TECHNICAL MEMORANDUM

Date: November 6, 2022
To: Brad Sturman, Sturman Architects
From: Ryan Kahlo, PWS
Project Name: Mercer Island Simpson
Project Number: 210734

Subject: Response to City Comments

This memorandum has been prepared in response to City of Mercer Island planning department comments regarding proposed reconstruction and expansion of a single-family residence located at 6454 E. Mercer Way in Mercer Island, Washington (parcel 3024059118). Comments were provided by Molly McGuire on the project plan sets on 8/2/2022.

A1.1

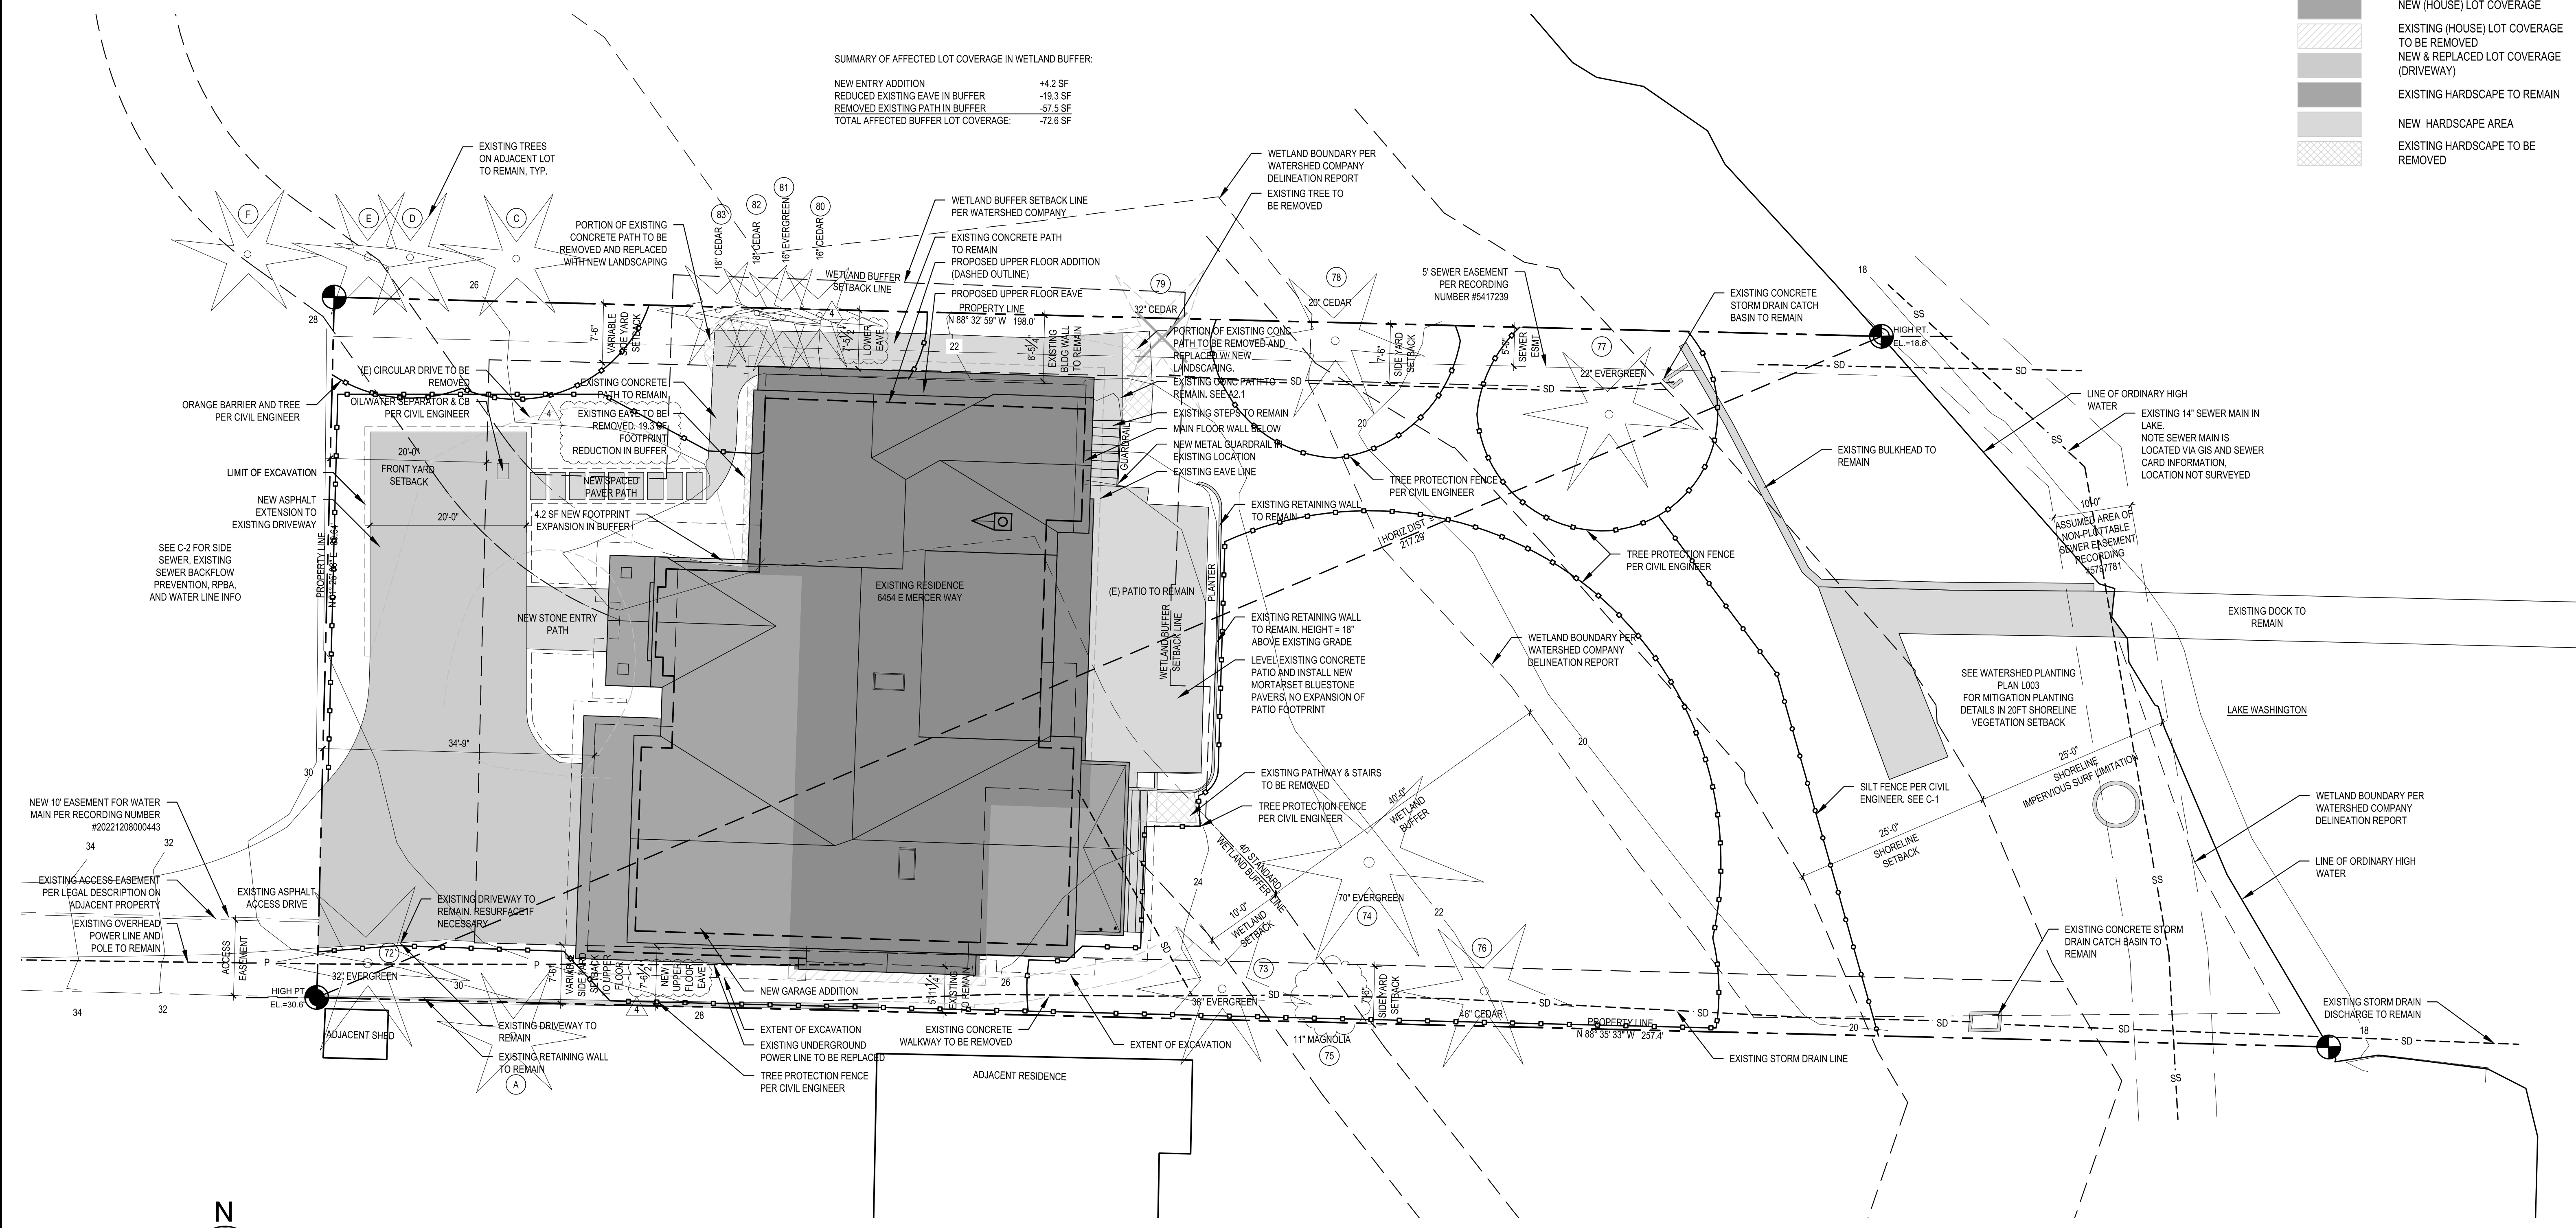
The existing single family residence is legally nonconforming. Additions to the residence are allowed as long as the footprint is not increased more than 200 sf. The upper floor addition is allowed as proposed under MICC 19.07.130(A)(2) Modifications, but this does not change the location of the wetland buffer or buffer setback.

This should be 30'. The standard wetland buffer does not go around the house. Please revise the plans so that we can see the wetland buffer consistently at 30' & 40' from the edge of the wetland boundary.

The standard wetland buffer does not go around the house. Please revise the plans so that we can see the wetland buffer consistently at 30' & 40' from the edge of the wetland boundary.

The wetland buffer and setback are depicted correctly on the project plans. ESA's peer review letter notes that the 40-foot buffer is correct. Since the legally established residence is partially located within the 40-foot buffer, the associated existing 10-foot building setback is applied around the edge of the existing structure, which is shown on the project plans. The depiction of the buffer as shown on the project plans was confirmed as correct in my conversation with Matt Maynard (10/28/2022).

The standard wetland buffer is 40 feet. See response above regarding depiction of the buffer and setback areas around the legally established structure within the 40-foot buffer. Buffer averaging is not proposed.

The correct standard wetland buffer is 40 and correctly depicted. See previous responses regarding this issue.

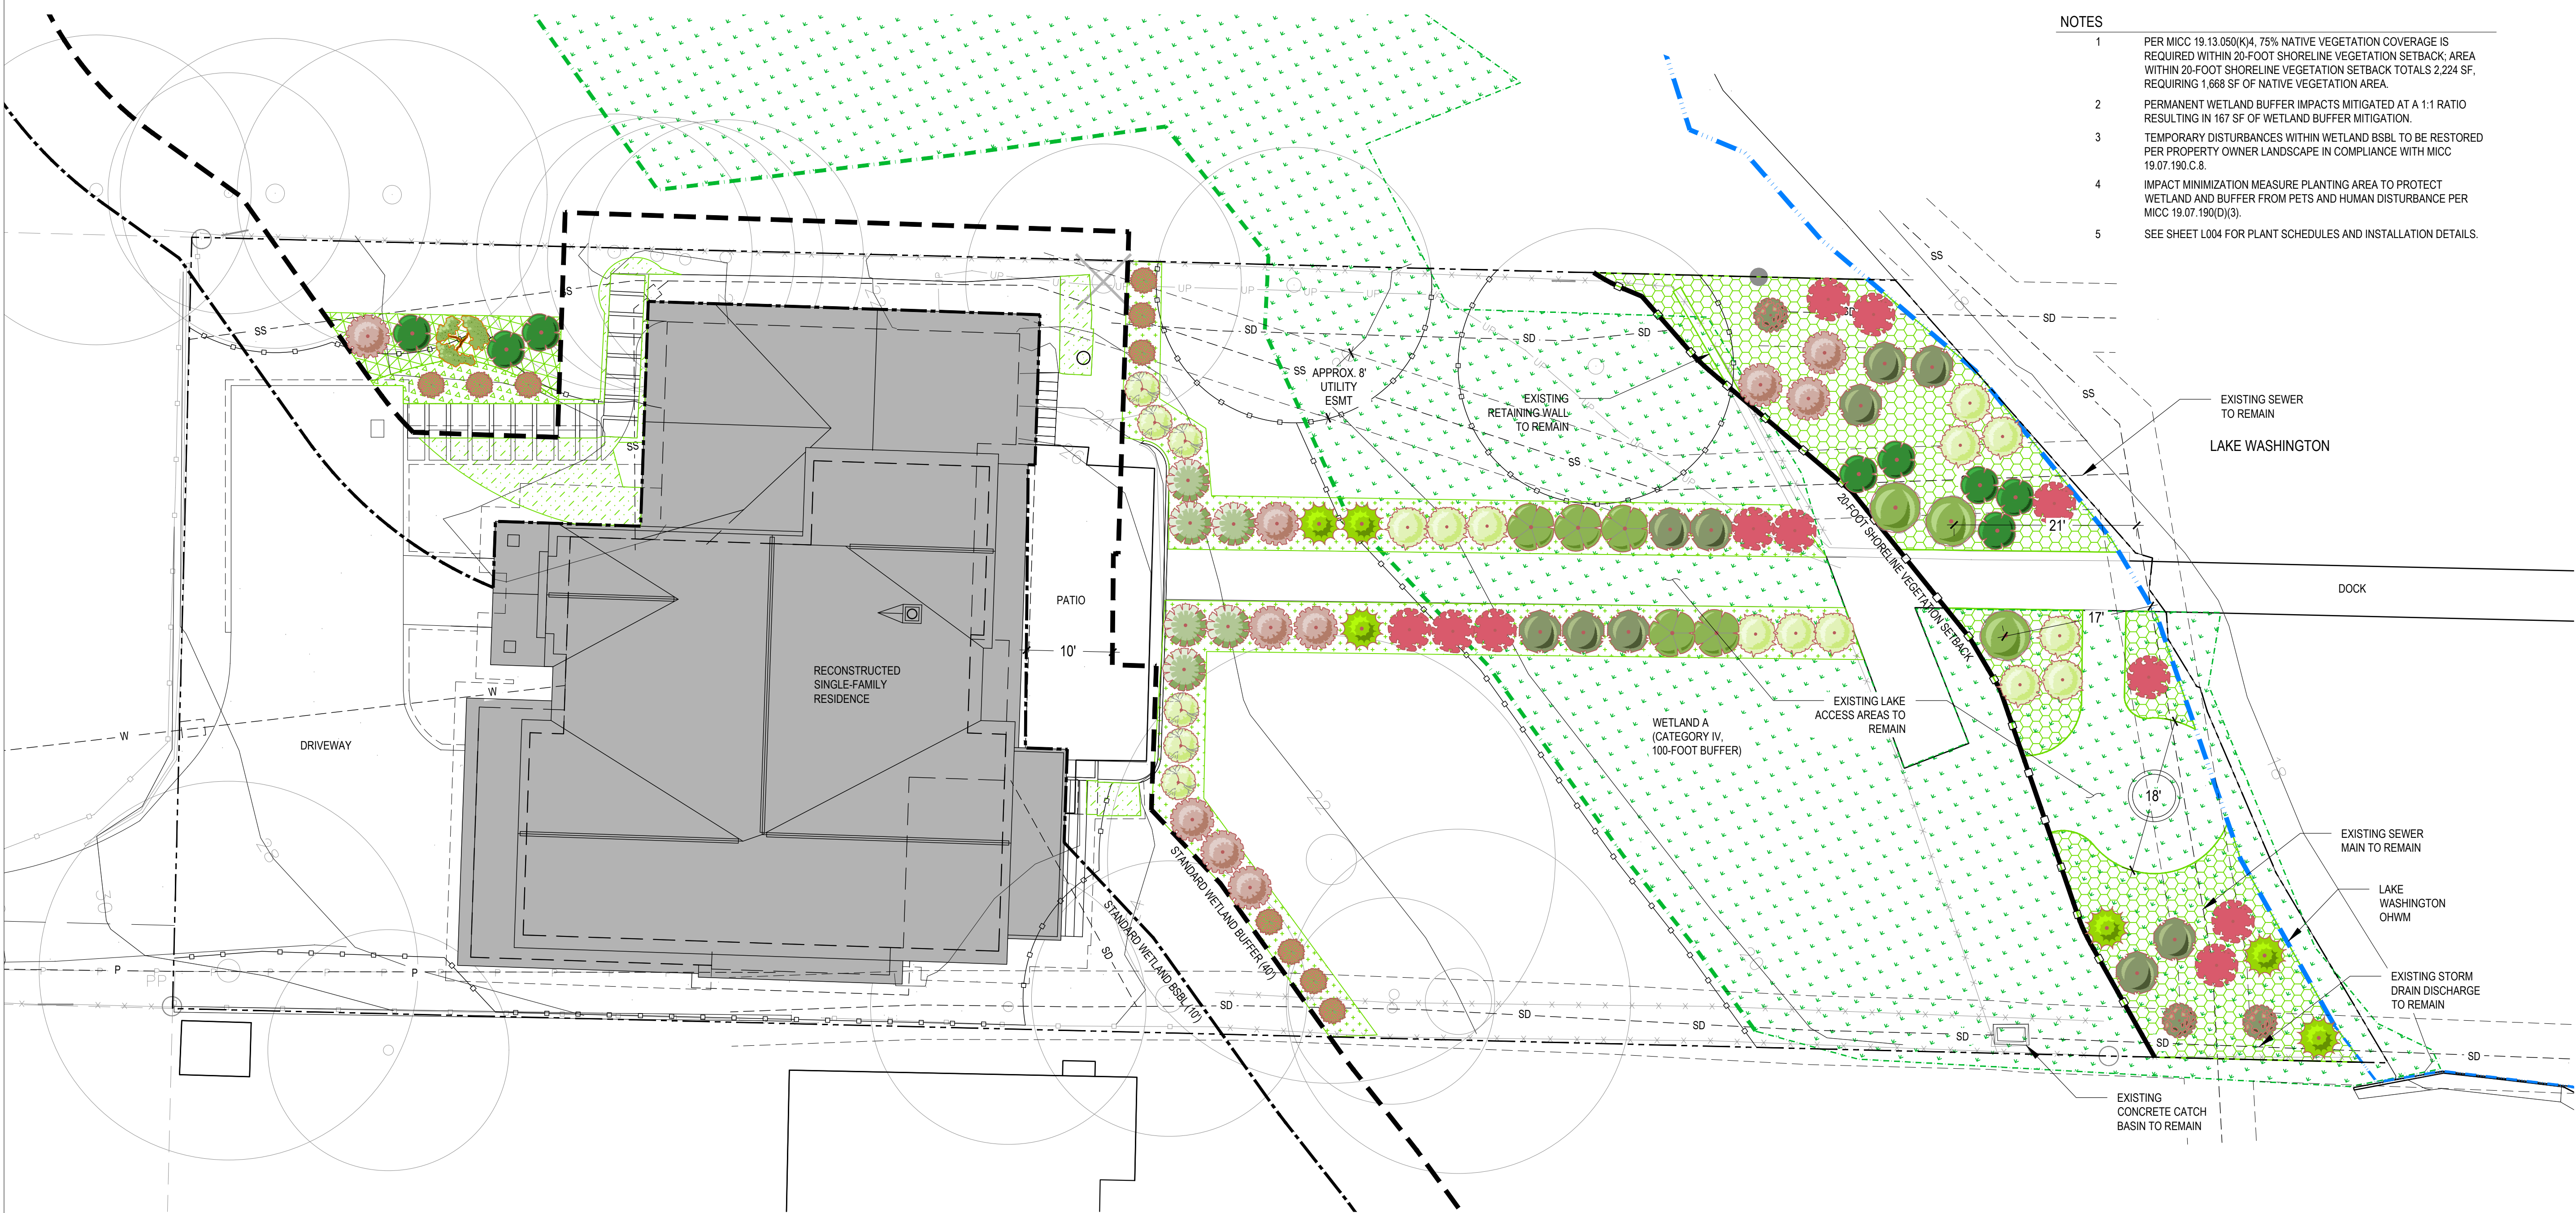
MICC does not have any provisions that allow wetland buffer to be converted to setback. If you are intending to take advantage of the buffer averaging provisions in MICC 19.07.190(C)(5), you will need to apply for a CAR2 permit instead, since buffer averaging is not included in a CAR1 permit. You will also need to demonstrate compliance with this section, such as the buffer not being reduced to less than 75% of the standard buffer. The Critical Area Report submitted must be revised to resolve the buffer conversion issue.

I discussed the conversion of buffer to setback with the City's on-call peer review consultant, Environmental Science Associates (ESA) (Matt Maynard, personal communication 10/28/2022). Mr. Maynard agreed that MICC 19.07.130(A)(2), which allows up to 200 square feet of residential expansion within a wetland buffer, is intended to apply to expansions in the setback that, by association, will convert buffer to setback. The interpretation is logical, since any allowed expansion within the buffer will inherently necessitate conversion of other portions of the buffer to building setback. Mr. Maynard indicated he would be preparing an addendum to his 10/25/2022 peer review

The remainder of this comment is not applicable. The applicant is not proposing buffer averaging.
